RESIDENTIAL

Address: ~~18420~~ N MERIDIAN RD, ELBERT

Plan Track #: 191939 Received: 15-Jul-2024 (QUINTONW)

Description: **RESIDENCE** Required PPRBD Departments (6)

**MAIN FLOOR PLAN**  
 SCALE: 1/4" = 1'-0"

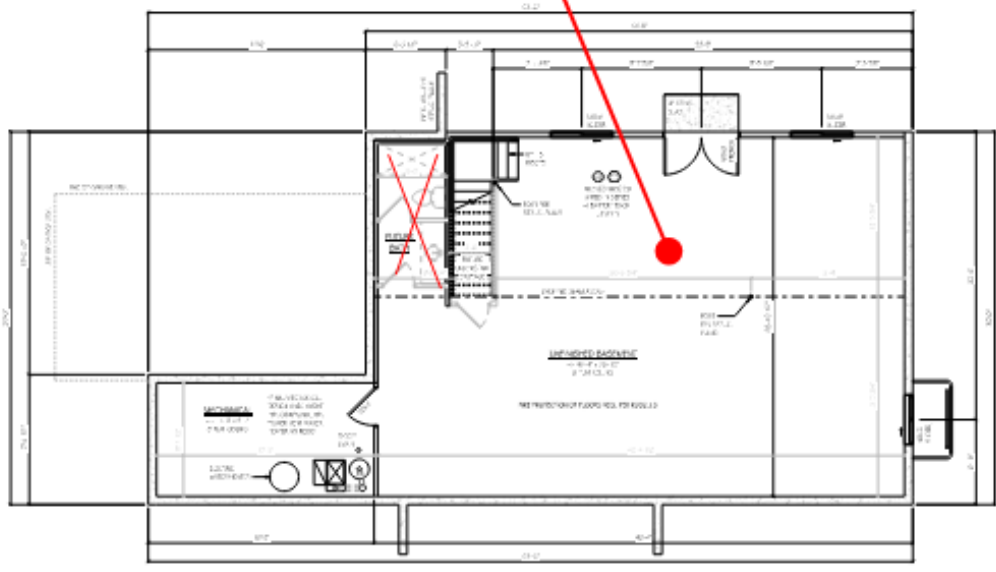
CONDITION OF APPROVAL
UNFINISHED BASEMENT TO REMAIN UNFINISHED
 ALSO: SPECIAL USE FOR AN ACCESSORY LIVING QUARTERS
 EXTENSIONS: 2. Special Use approval includes conditions of approval and the accompanying site plan and elevation drawings.
 No substantial expansion, enlargement, intensification or modification shall be allowed except upon reevaluation and public hearing as specified in the El Paso County Land Development Code.

SPECIAL NOTE:
 LIVING SPACE OF MAIN FLOOR 4,326 sf
 IF THE BASEMENT IS FINISHED THEN
 LIVING SPACE IS 4,646 WHICH EXCEEDS
 THE 1,560 sf OF ALLOWABLE AGD LIVING SPACE

**BASEMENT FLOOR PLAN**  
 SCALE: 1/4" = 1'-0"

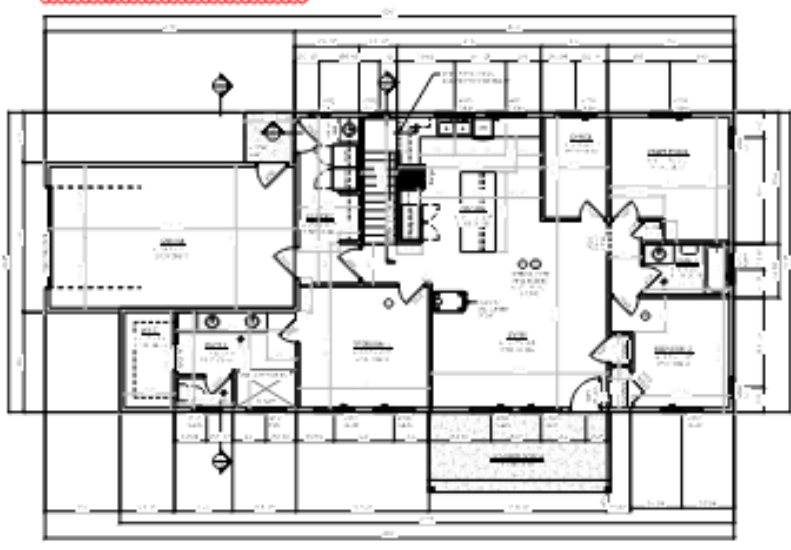
CONDITION OF APPROVAL
UNFINISHED BASEMENT TO REMAIN UNFINISHED
 ALSO: SPECIAL USE FOR AN ACCESSORY LIVING QUARTERS
 EXTENSIONS: 2. Special Use approval includes conditions of approval and the accompanying site plan and elevation drawings.
 No substantial expansion, enlargement, intensification or modification shall be allowed except upon reevaluation and public hearing as specified in the El Paso County Land Development Code.

SPECIAL NOTE:
 LIVING SPACE OF MAIN FLOOR 4,326 sf
 IF THE BASEMENT IS FINISHED THEN
 LIVING SPACE IS 4,646 WHICH EXCEEDS
 THE 1,560 sf OF ALLOWABLE AGD LIVING SPACE
